Engineers Comments Regarding Condition 3- surface water drainage

APPLICATION **BR/126/19/DOC**

Site Address: 65C Gravits Lane Bognor Regis PO21 5LN

Description of Works: Aproval of matters reserved by condition fimpoused under
BR/208/14/PL relating to condition 3-surface water drainage.

LOCATION PLAN
65C GRAVITS LANE BOGNOR REGIS

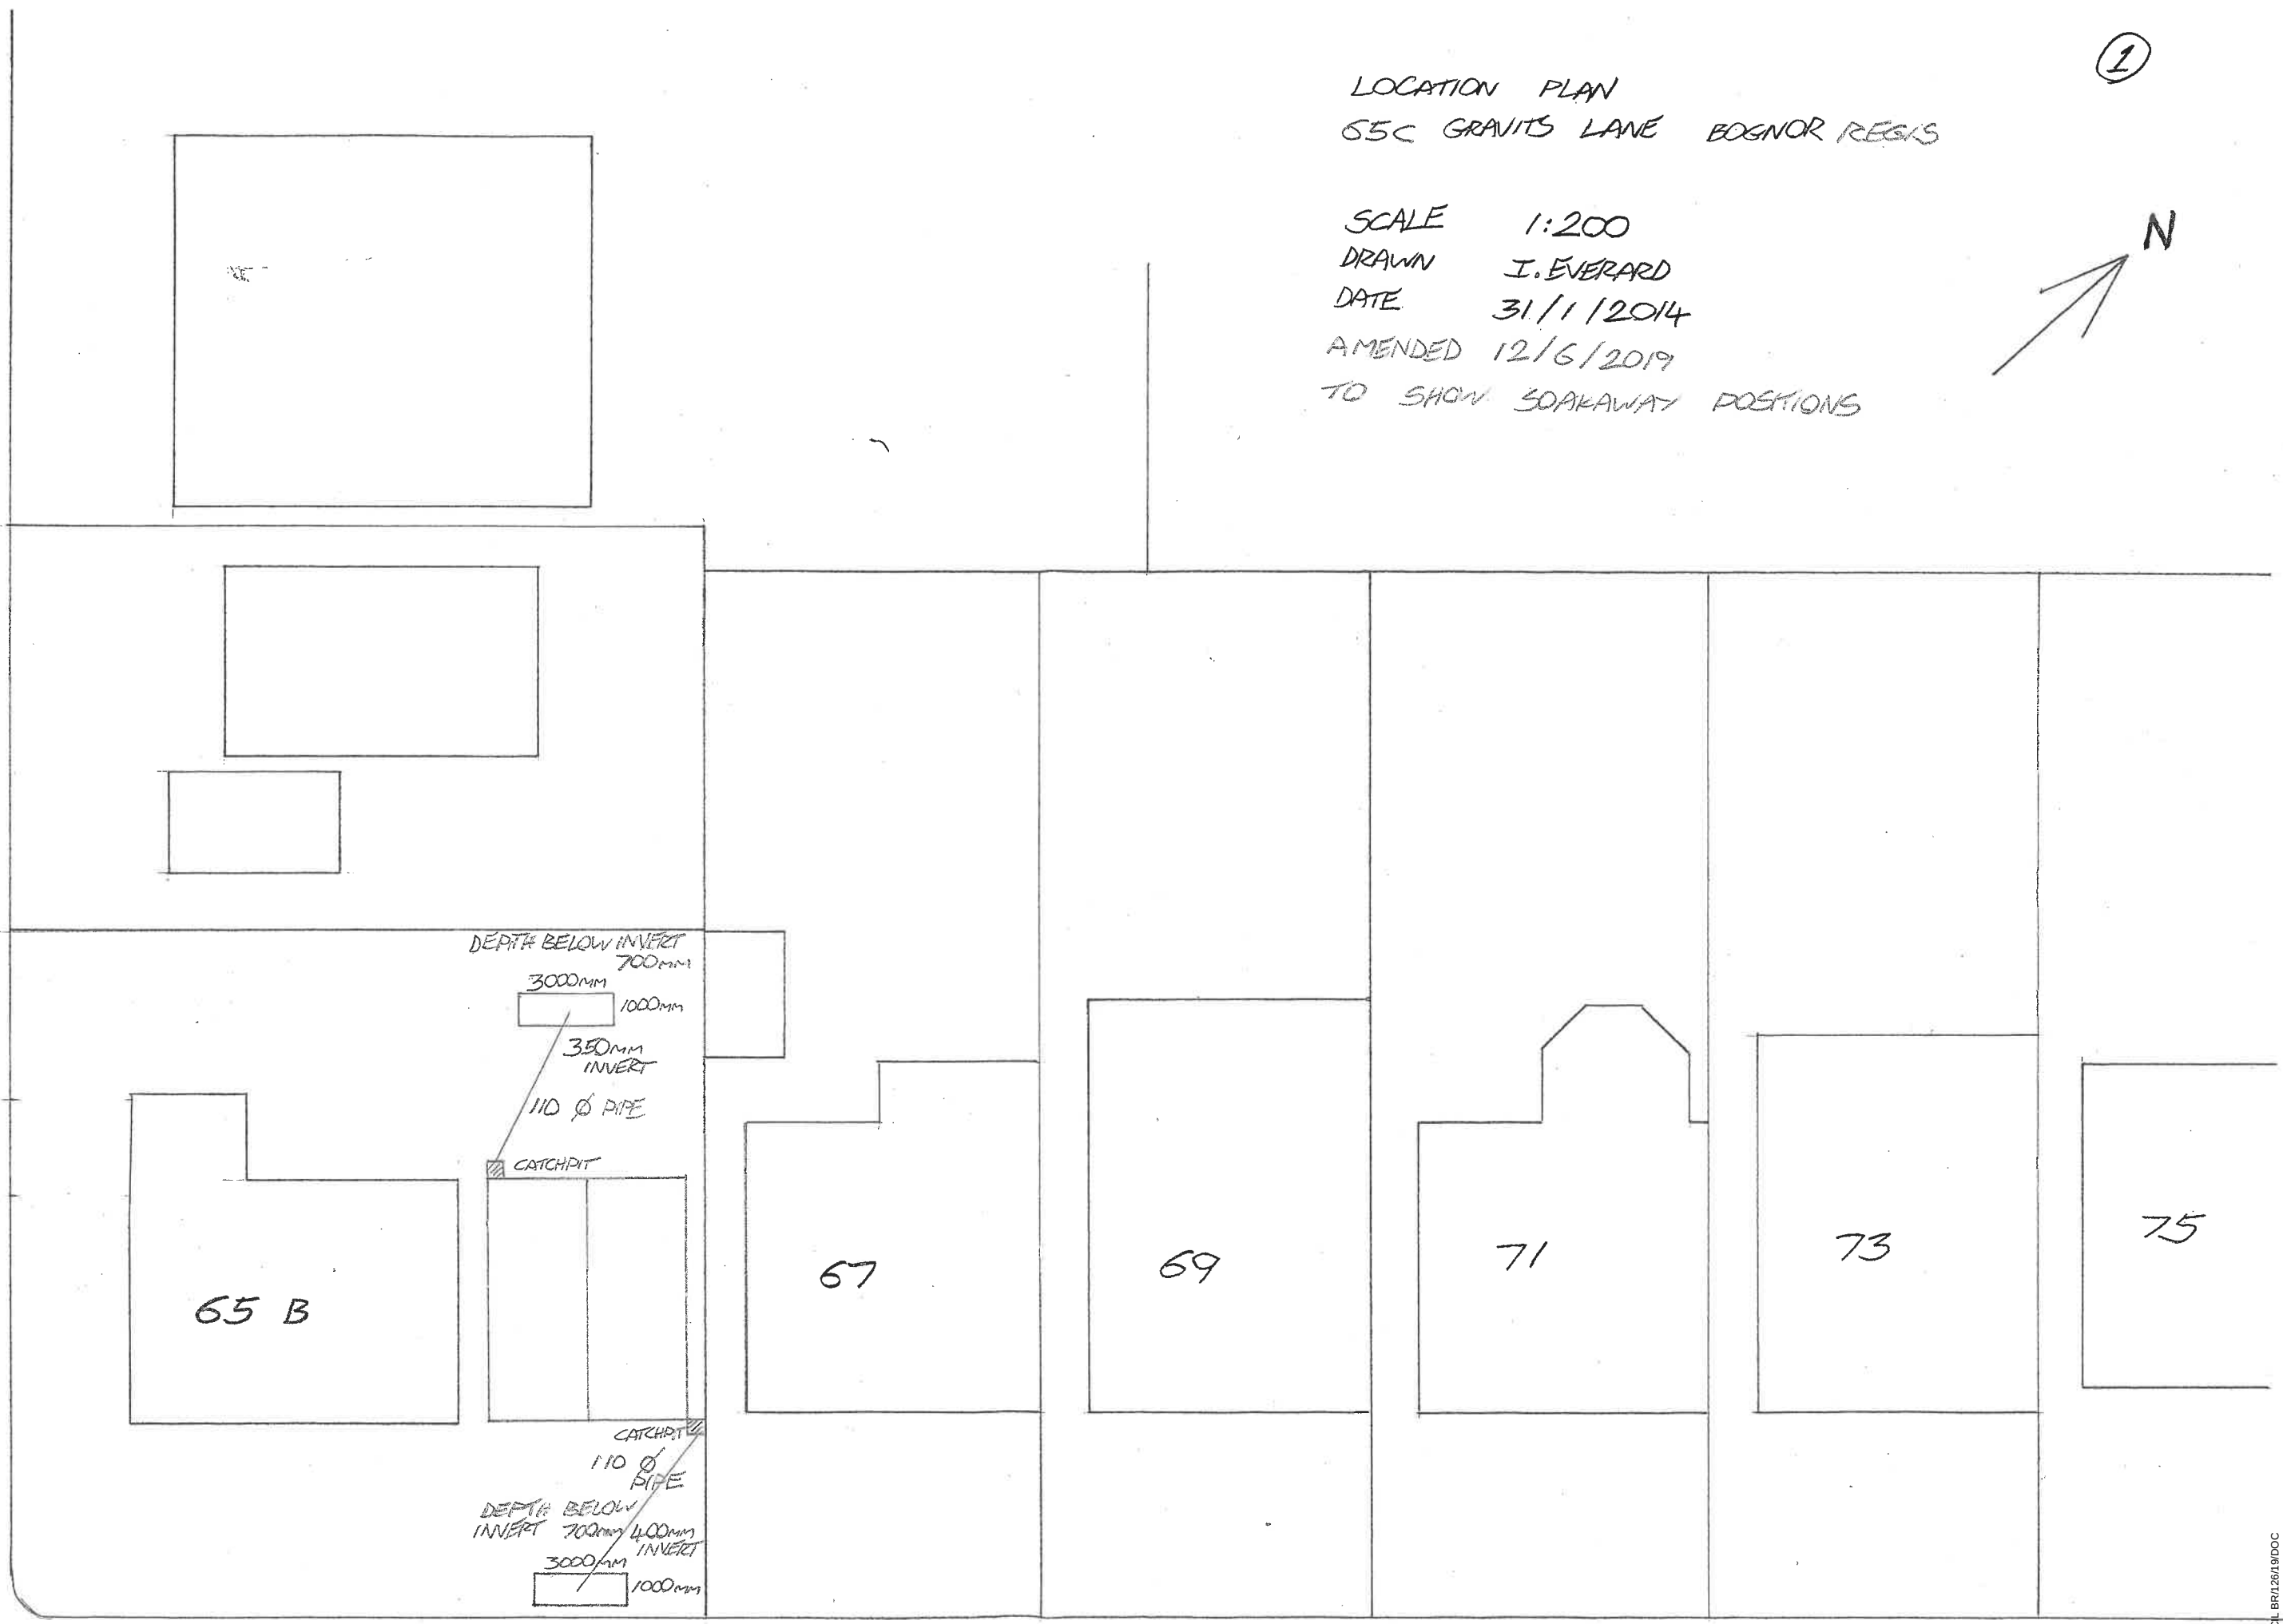
1. Insufficient storm durations have been detailed within calculations. Storm durations between 5 minutes and 24 hours should be examined.
2. Please can the applicant confirm when infiltration testing was completed, and to what depth.
3. Construction detail drawings are required.
4. Layout drawings need to be provided to scale and detailing proposed soakaway dimensions including invert and cover levels.
5. Catchpits need to be shown on plan upstream of all connections to soakaways.
